# COLORADO

## Parks and Wildlife

December 10, 2020

Re: Miles Subdivision 1

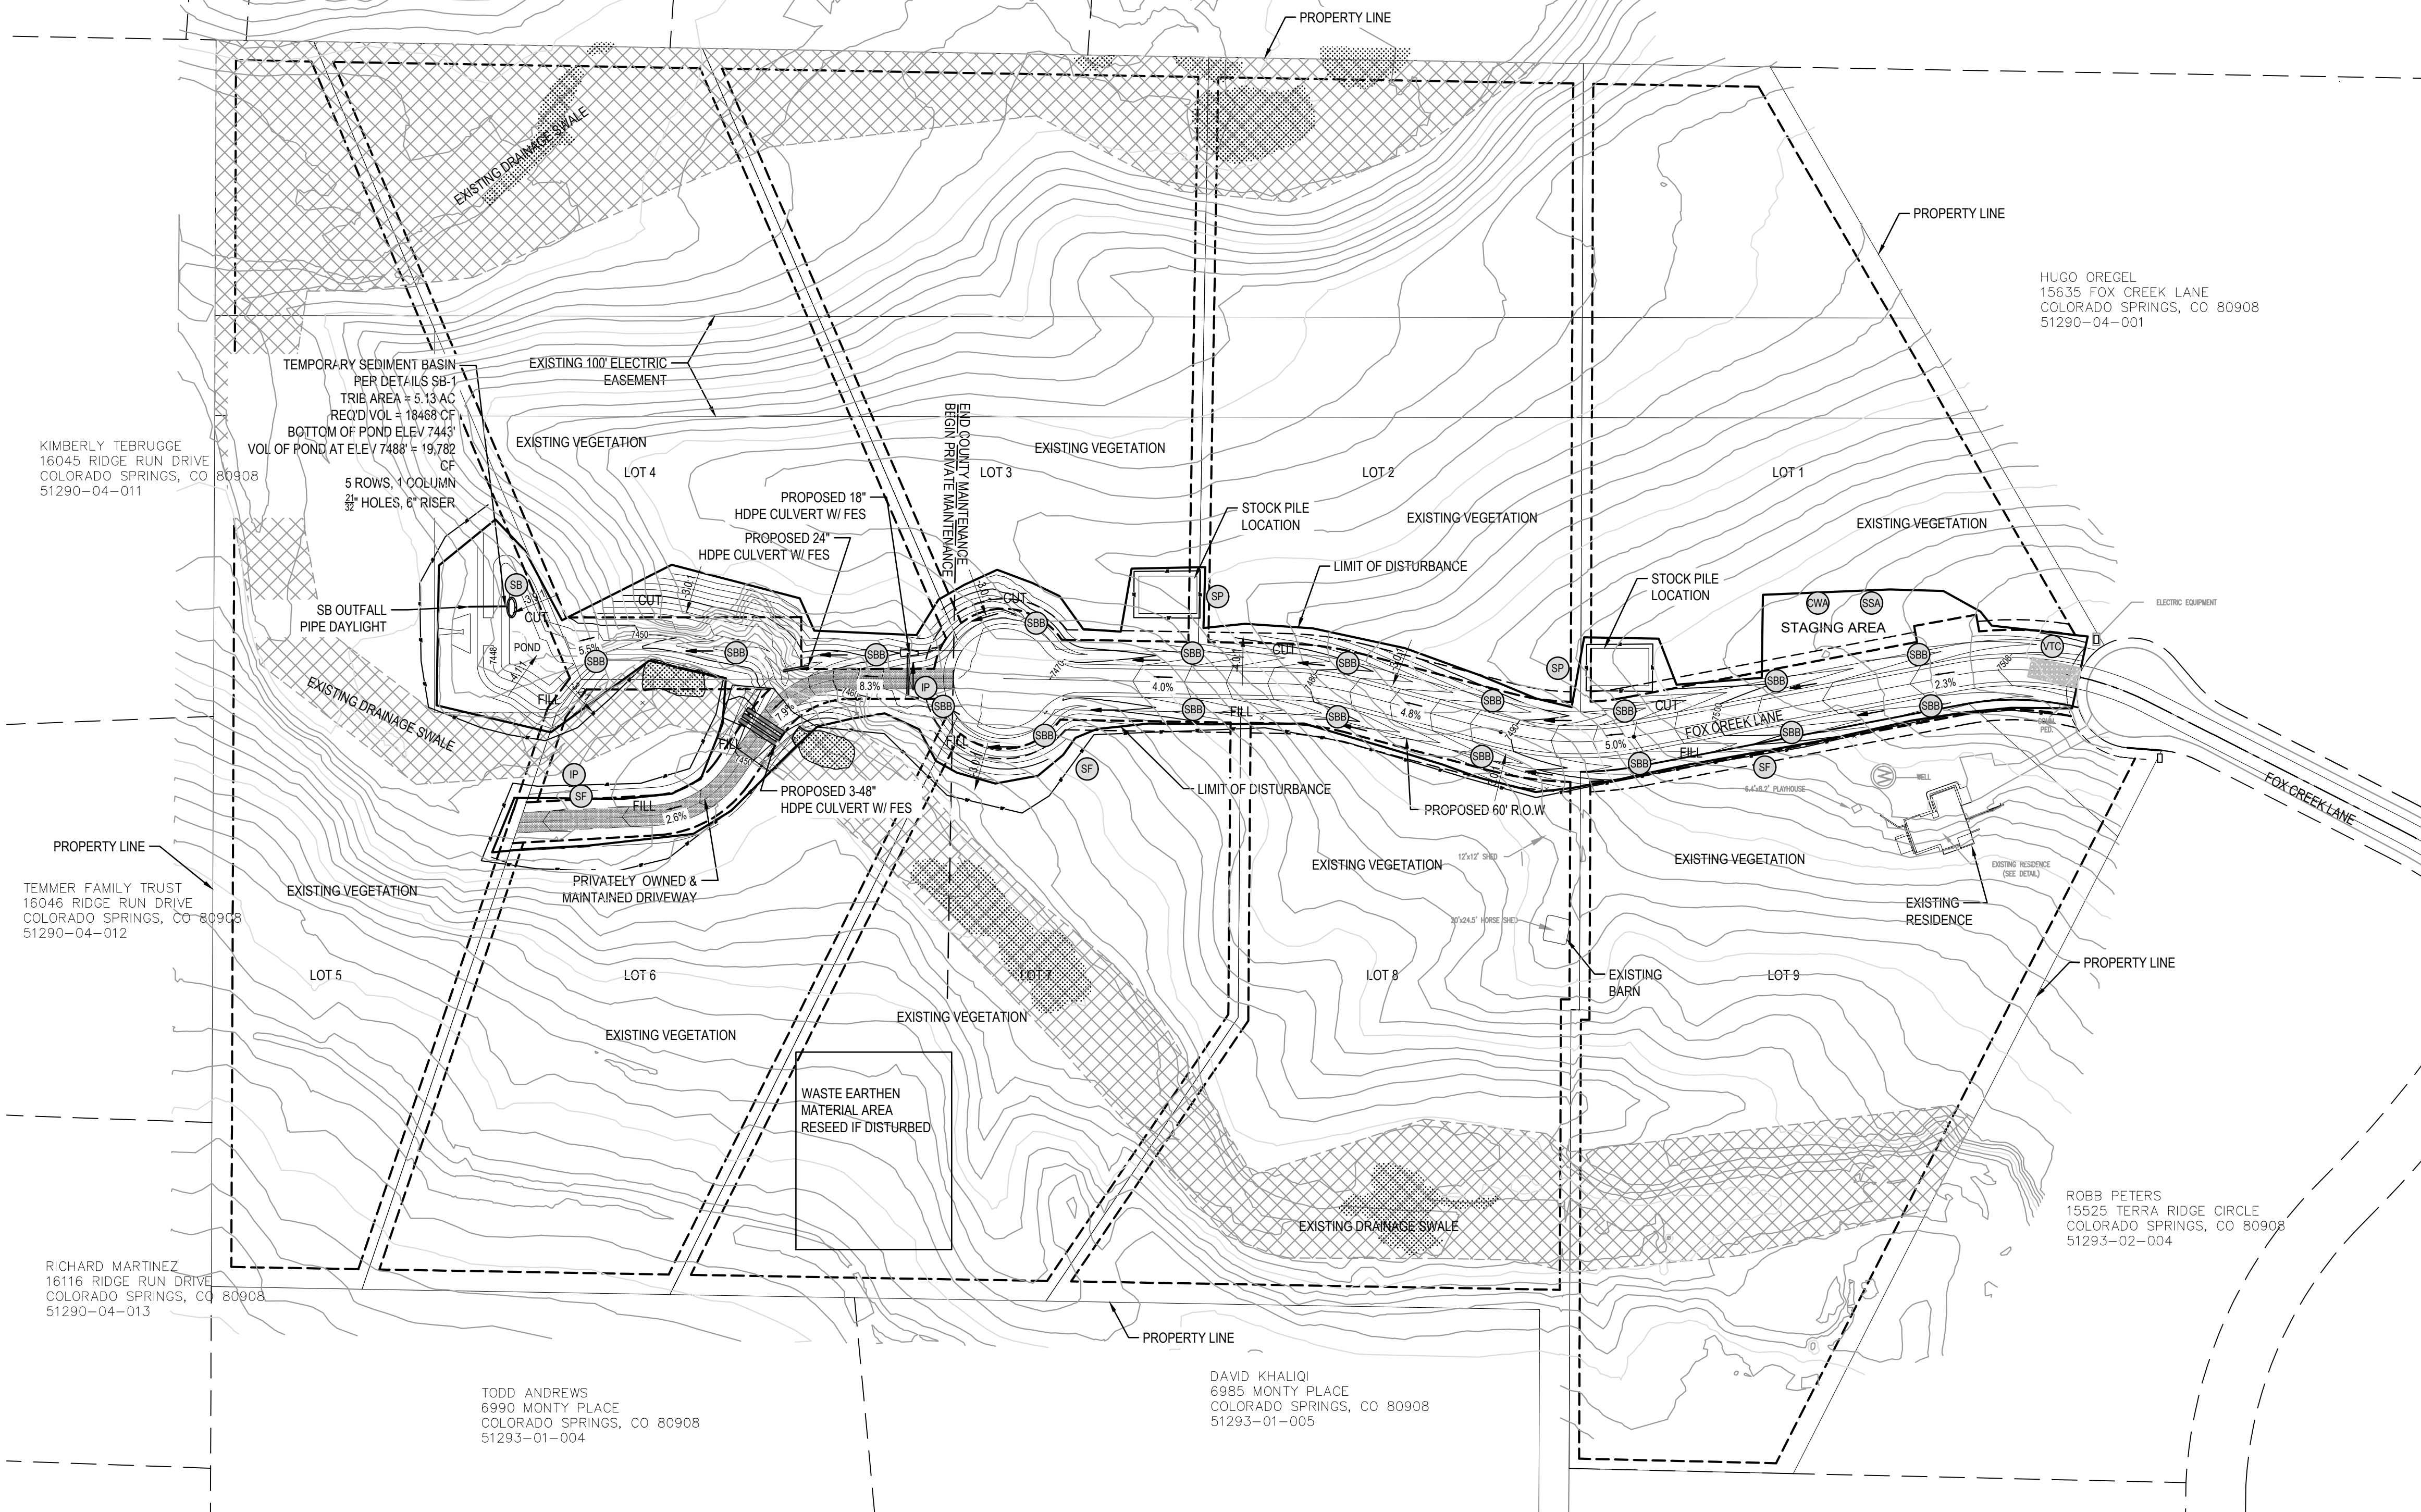
In the Preliminary Plan for this project, the drawings show that there are houses proposed to be built in the drainage on the property that was designated “Freshwater Emergent Wetland” according to the US Fish and Wildlife Service National Wetlands Inventory report attached to the filing. A proposed grading of the channel of this wetland was also shown in the Preliminary Plan.

CPW recommends that no dwellings or buildings are built in the middle of the drainage for both flood safety issues, as well as habitat degradation issues. CPW further recommends, if you build in the vicinity of the wetland or waterway, that during construction all crossings of riparian corridors and streams occurs at a perpendicular angle, in order to reduce impacts to natural resources, as well as spanning the corridors with structures located outside the riparian and stream zone. CPW recommends avoiding treed areas of cottonwood and willow, as these areas provide bird and wildlife habitat. Stream crossing by construction vehicles should be avoided. CPW requests that any new service roads that are proposed for construction in conjunction with the project avoid crossing creeks or stream beds to avoid impacts to wildlife and habitat. If any new access or maintenance roads will be constructed that cross stream habitat, CPW would like to be consulted on best management practices and options for construction to minimize impacts. A construction design for any new or

CPW, in general, prefers that drainages are altered to the minimum extent possible, so that naturally occurring drainages continue to provide wildlife habitat that is as close to unaltered as possible. If the project continues as planned, CPW also recommends that all areas of disturbance and exposed soils above the ordinary high water mark be re-vegetated with a native seed mix. This will contribute to the replacement of lost riparian vegetation values and minimize establishment of noxious weeds. The placement of willow sprigs or bare root stock should also be considered along the banks, especially in those areas which have been disturbed. CPW recommends planting of vegetation along the bank to help reduce and control erosion and contribute to bank stability over the long term. The site should be monitored for a period of at least two growing seasons.
